Ribble Valley Borough Council

DELEGATED ITEM FILE REPORT - REFUSAL

Application No:	3/2015/0549/P
Site:	7 Hospital Cottages, Ribchester Road, Ribchester, PR3 3YA
Development Proposed:	First floor extension over existing ground floor extension.
Target:	4 th September 2015

TITLE:	Rear Elevation		
CLIENT:	Mr. S. M. Clash		
UNITS:	mm UNLESS STATED OTHERWISE		
SCALE:	1:50	SHEET:	A3
DRAWN BY:	L. ASHMORE	DATE:	18/05/2015
CHECKED BY:		DATE:	
APPROVED BY:		DATE:	
DRAWING No.	LA/0003/28	REV:	0
DRAWING Ref:	Existing Layout

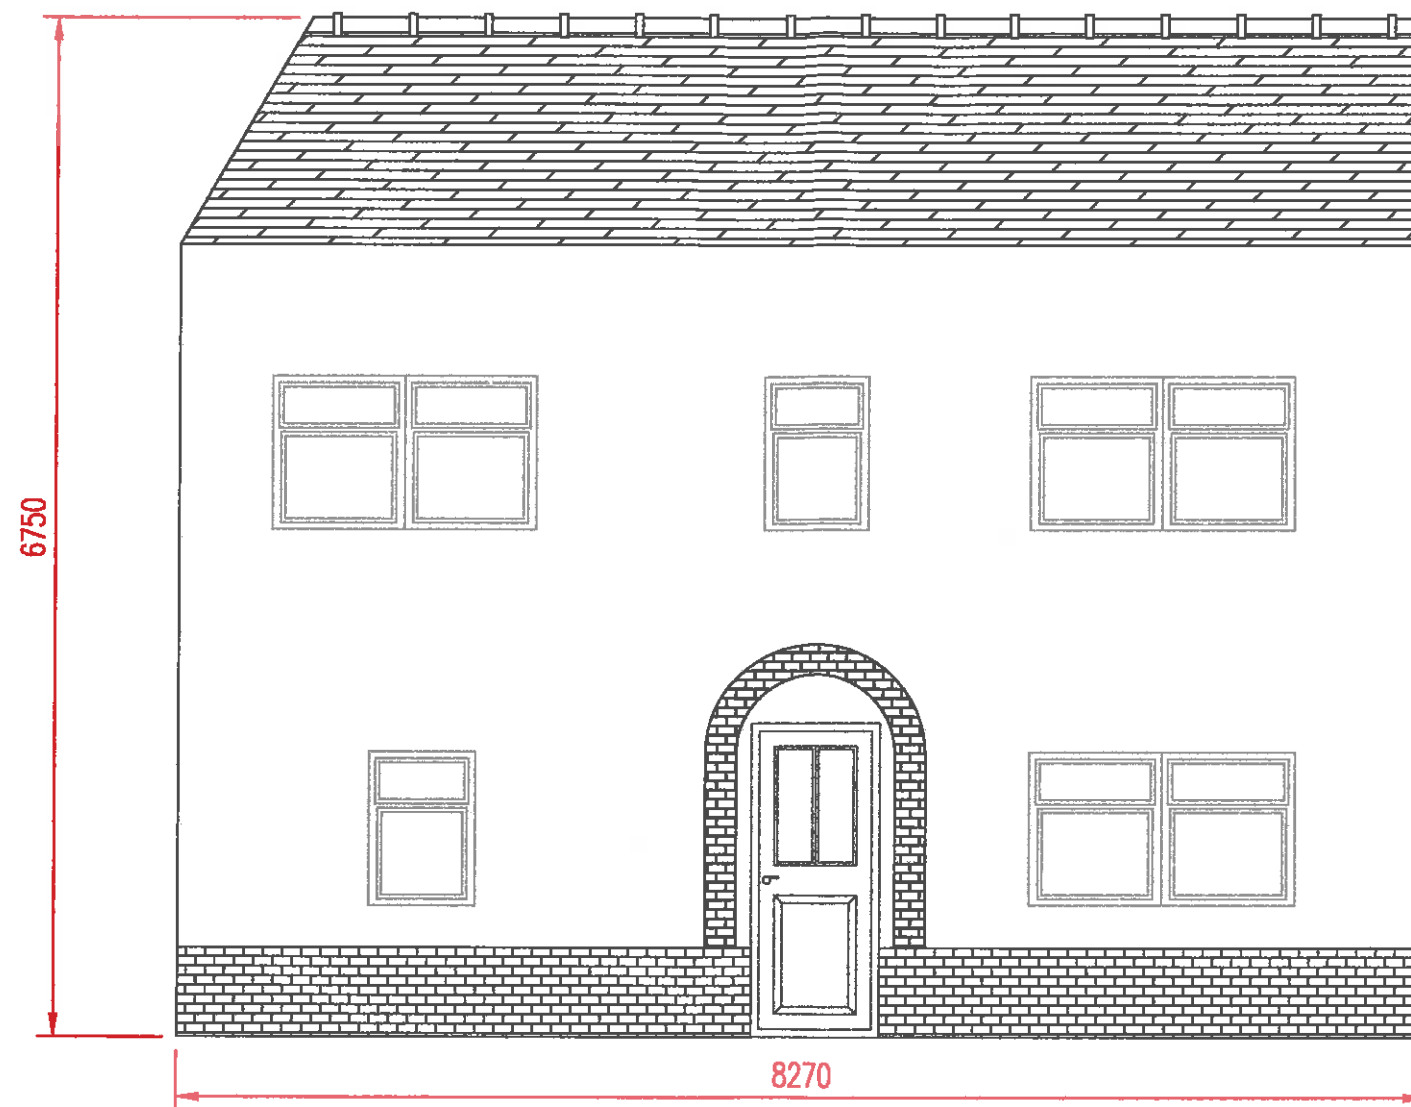
The proposed development would be situated to the rear of the application property and as such would not be prominent in the streetscene. However, it would be a prominent feature in the context of the rear gardens of the immediate properties in the area. Ribble Valley Core Strategy Policy DMG1 provides specific guidance in relation to design and states that extensions should be designed to complement the original dwelling in terms of its scale, massing, style, features and building materials. The proposed two storey rear extension would impact on the character of the host dwelling due to the increase in mass to the rear. The proposed extension would not be set down from the main dwelling at the eaves or ridge nor would it be set in from the gable elevations and it would fail to appear subservient to the application property. As a result, it would completely overwhelm and wholly dominate the application property on both side and rear elevations. The proposed development would be an incongruous and bulky addition and would be seriously detrimental to the appearance and character of the host dwelling and the surrounding area by virtue of its design, scale and size. Furthermore, the proposed window openings on the rear elevation would not respect the existing window arrangement or the style

and proportions of existing openings resulting in further visual harm. In addition, it is considered the approval of the scheme would create a harmful precedent for the acceptance of other similar unjustified proposals at neighbouring dwellings. The proposals are considered contrary to policies DMB1 and DHM5 of the Core Strategy.
